Rezoning Transportation Analysis

Petition Number: Insert Zoning Petition #2022-005

Revision Log:	Date	Description
	06-23-22	First Review (TM)
	08-22-23	Second Review (IW)

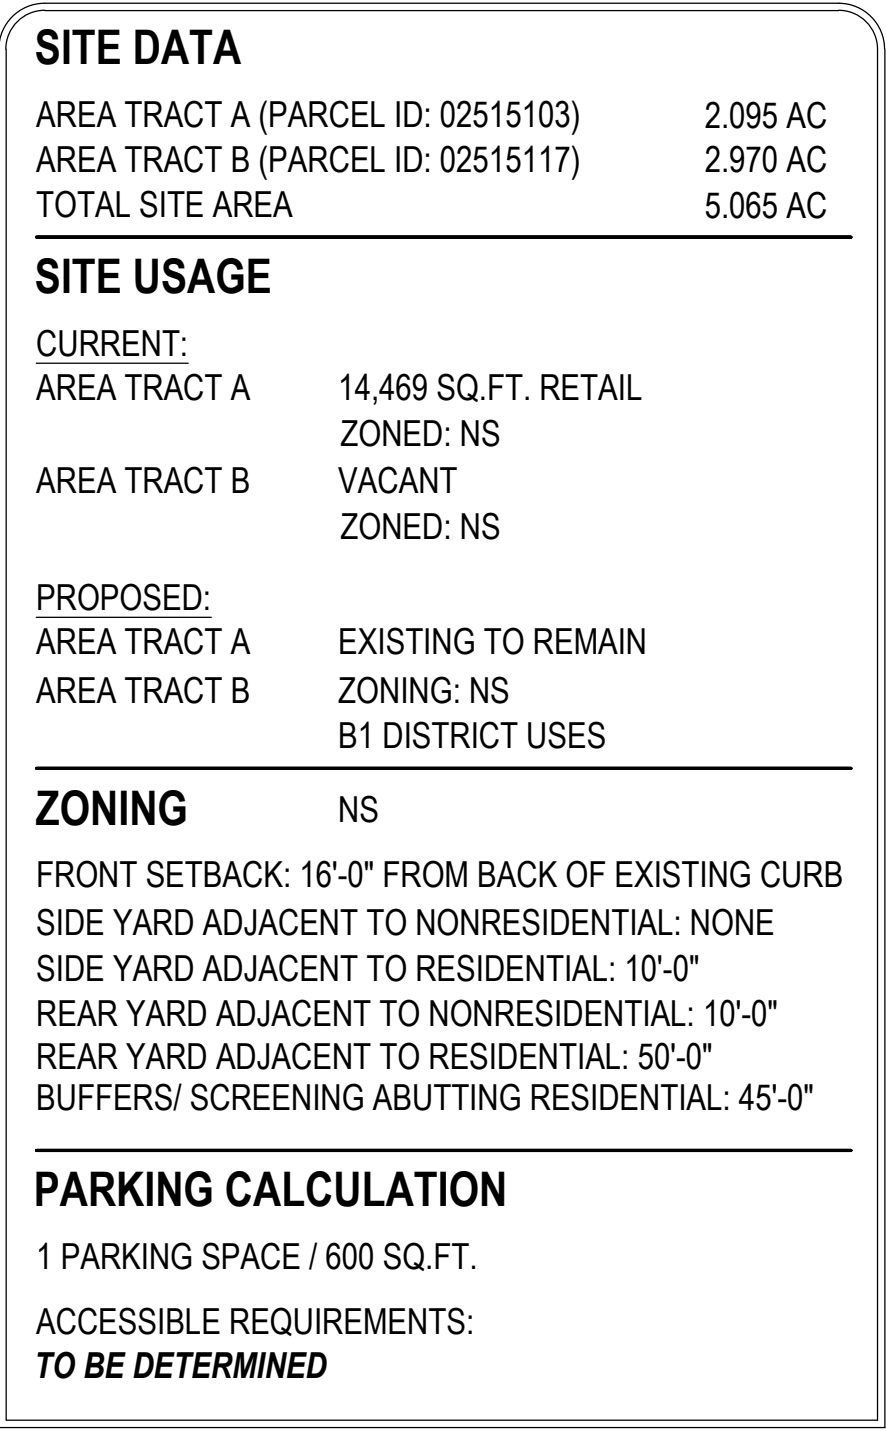
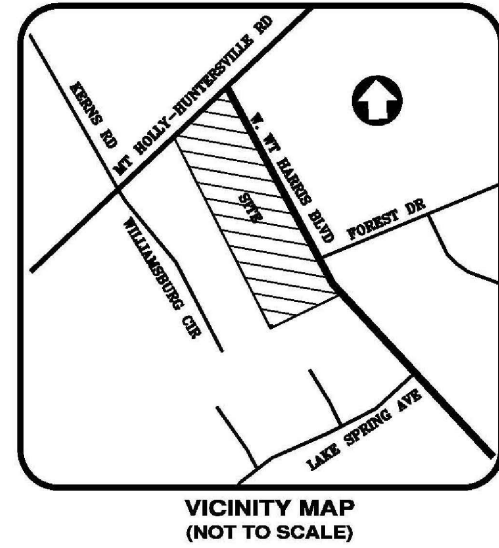
1. ~~**Curbline:** The proposed zoning district has a setback measured from back of the future curbline.~~
 - a. ~~**W T Harris Boulevard:** Location of curb and gutter is 33' from the centerline of W T Harris Boulevard.~~

~~Label and dimension the curb and gutter from the centerline for each road on the site plan.~~
2. **Traffic Study:**

3. ~~Revise site plan and conditional note(s) to commit to dedicate a minimum of 50 feet of right of way from the road centerline. The site plan shall label and dimension the right of way from the road centerline. If the proposed multi-use path is located outside of the right of way provide sidewalk utility easement located 2 feet behind the multi-use path.~~

4. ~~Per coordination with NCDOT, revise site plan and conditional note(s) to commit to widen WT Harris to provide two southbound through lanes fronting the site that tie into the existing two through lanes just south of project. In lieu of widening for an additional through lane, a right turn lane can be installed on WT Harris at the site access.~~

5. ~~Revise site plan to show access points for each proposed area from the existing access road.~~
6. ~~Revise site plan to commit to installing 8-foot planting strip and 12-foot multi-use path on WT Harris per Chapter 19. The wider sidewalk also meets the Charlotte Walks Policy and City of Charlotte BIKE Policy.~~

7. ~~A site plan note(s) specifying dedication and fee simple conveyance of all rights of way to the City before the site's first building certificate of occupancy is issued as needed. CDOT requests rights of way set at 2' behind back of sidewalk where feasible.~~

8. ~~Revise site plan and conditional note(s) to commit to reconstructing the site access driveway to meet standard CLDSM driveway detail 10.25E or 10.28. The site plan shall callout and dimension the driveway at the ROW line.~~
